DATE: August 9, 2019  
TO: Kari Parsons, PCD-Project Manager  
FROM: Kyle R. Campbell, P.E. – Division Manager  
SUBJECT: Response to “**SF-19-007– Midtown Collection at Hannah Ridge Filing 1 First Submittal**”, dated May 9, 2019

N:\111630\DRAWINGS\CONSTRUCTION\STREET\BA_05-111630-FI-5-01.dwg, 3/27/2019 2:43:51 PM, 1:1

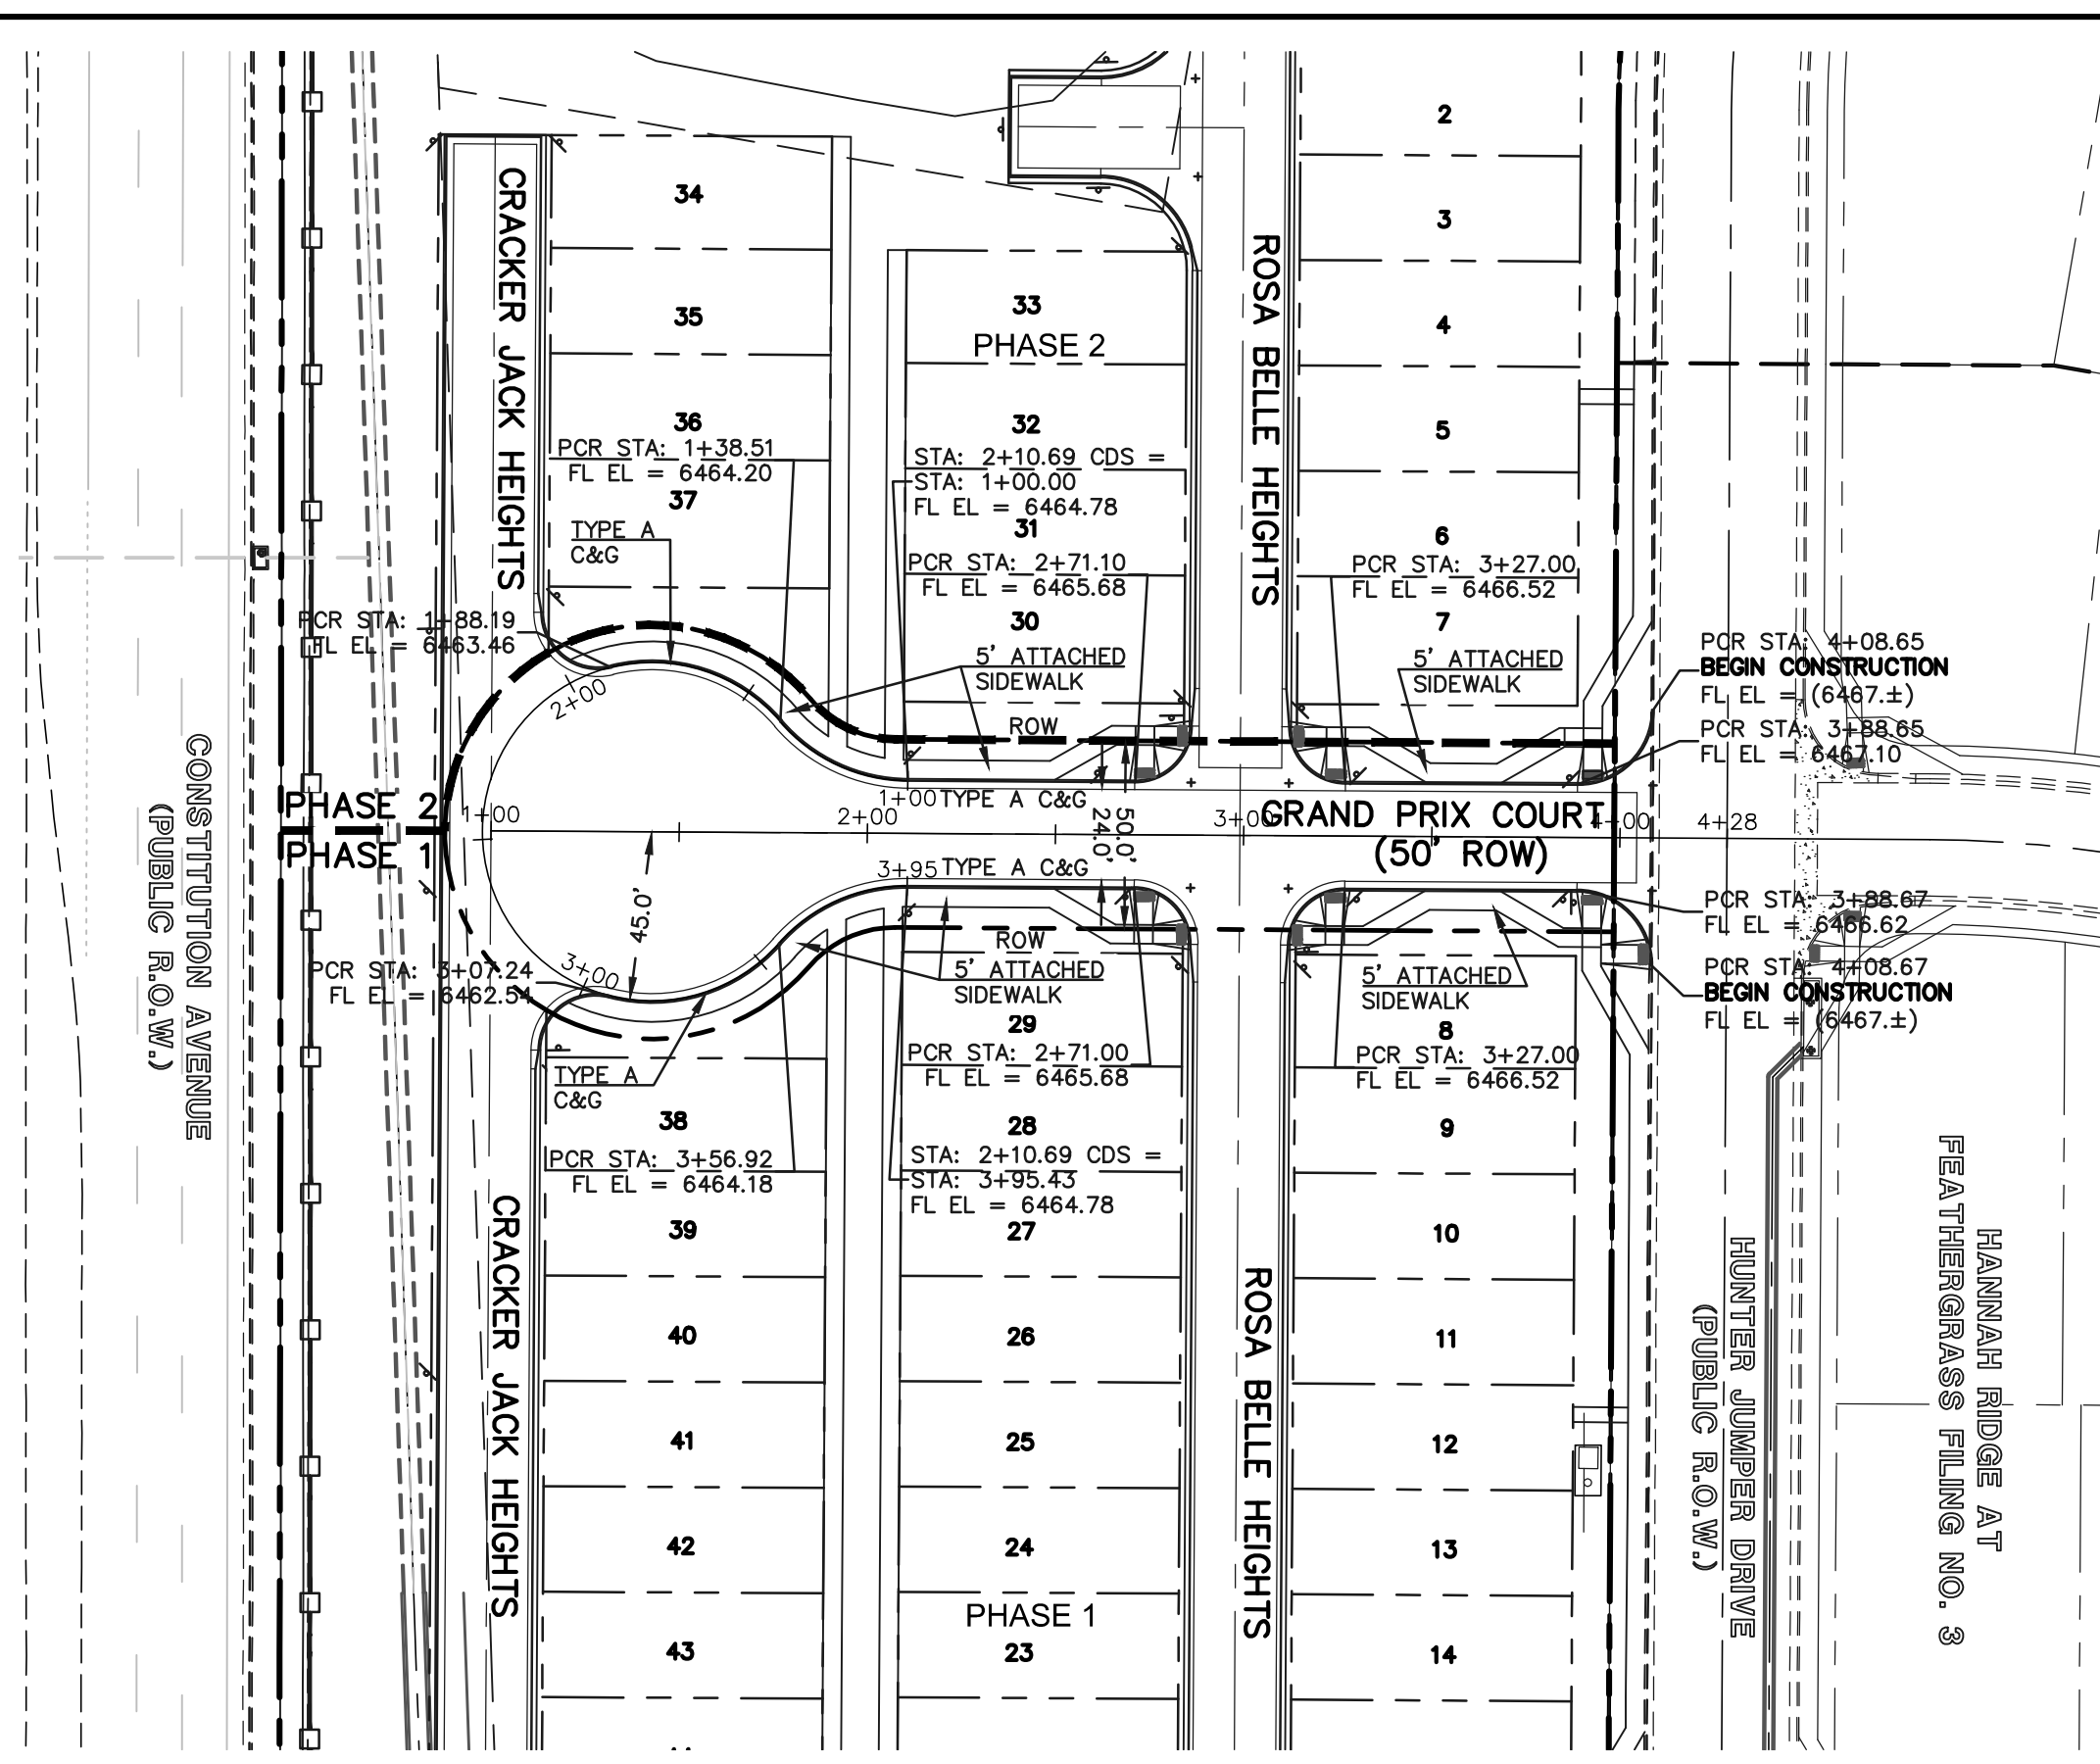
1. Assess the need for signage at the entrances and ends of the cul-de-sacs (W14-1/W14-2 and Type 4 object markers?).  
**RESPONSE: See revised plans.**

MIDTOWN COLLECTION AT HANNAH RIDGE
FILE NO. 1
STREET IMPROVEMENT PLANS
SUN CHASER - ROSSA BELLE - CRACKER JACK

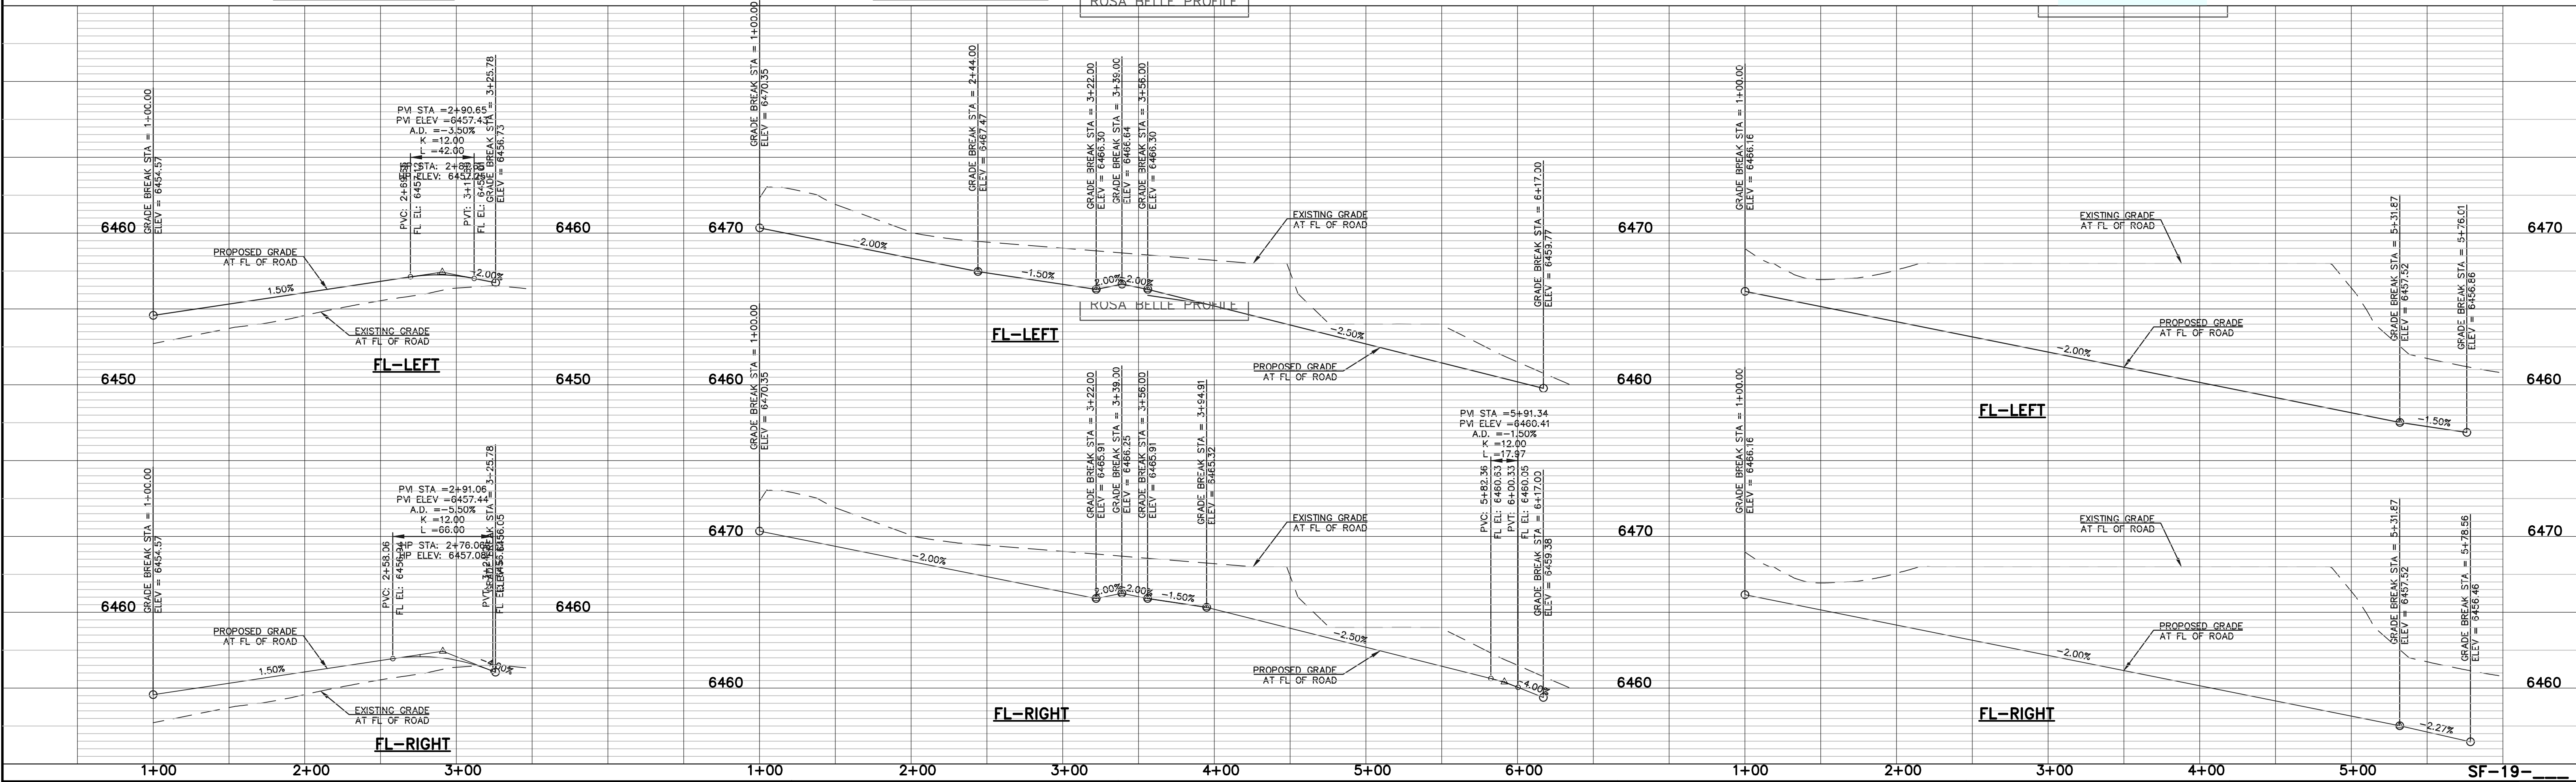
5. Show and label permanent BMP maintenance access roads on the plans.  
**RESPONSE: See revised.**
6. The standard detail sheet is not legible when printed; divide the details onto two or more sheets.  
**RESPONSE: See revised.**
7. Call out on the three-lot grading template exhibits the location of the sidewalk to ensure each lot has ADA accessibility.  
**RESPONSE: These lots are single-family detached, ADA accessibility not required.**
8. See CD redlines for additional comments.  
**RESPONSE: Acknowledged.**

MIDTOWN COLLECTION AT HANNAH RIDGE
FILING NO. 1
STREET IMPROVEMENT SIGNAGE PLAN

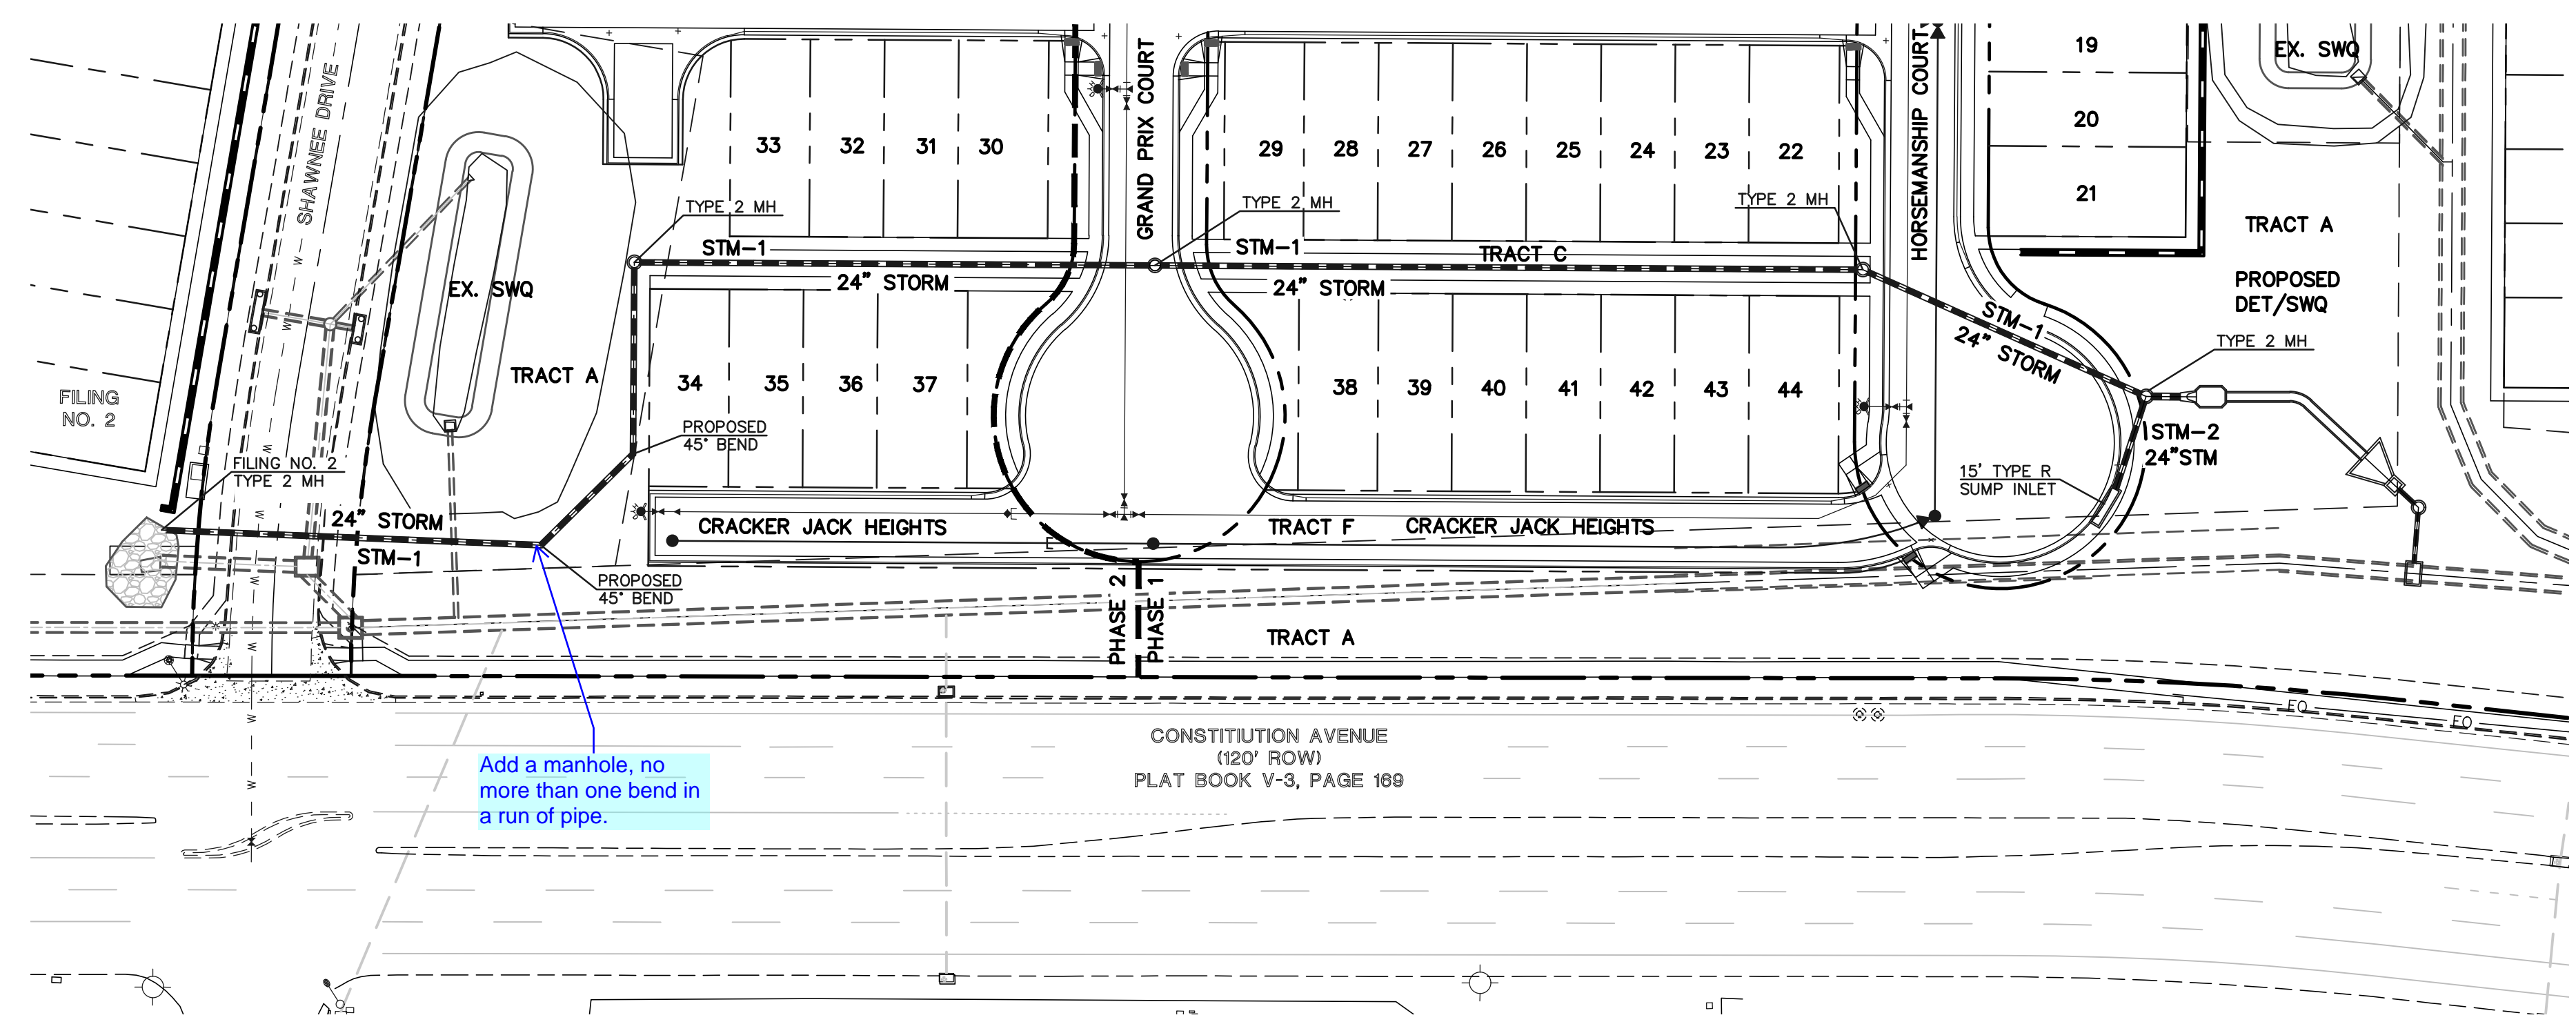
1. Clarify if the drainage easement along Constitution Ave. is public and the entity responsible for maintenance.  
**RESPONSE: Clarification added as requested.**
2. Provide notes indicating that the private roads are not County maintained and responsibility of the developer/builder to ensure ADA accessibility, since a majority of the sidewalk is to be constructed on private tracts owned and maintained by the Midtown Collection at Hannah Ridge Homeowners association (see redlines).  
**RESPONSE: Additional notes added.**
3. See final plat redlines for additional comments.  
**RESPONSE: Revised as requested.**
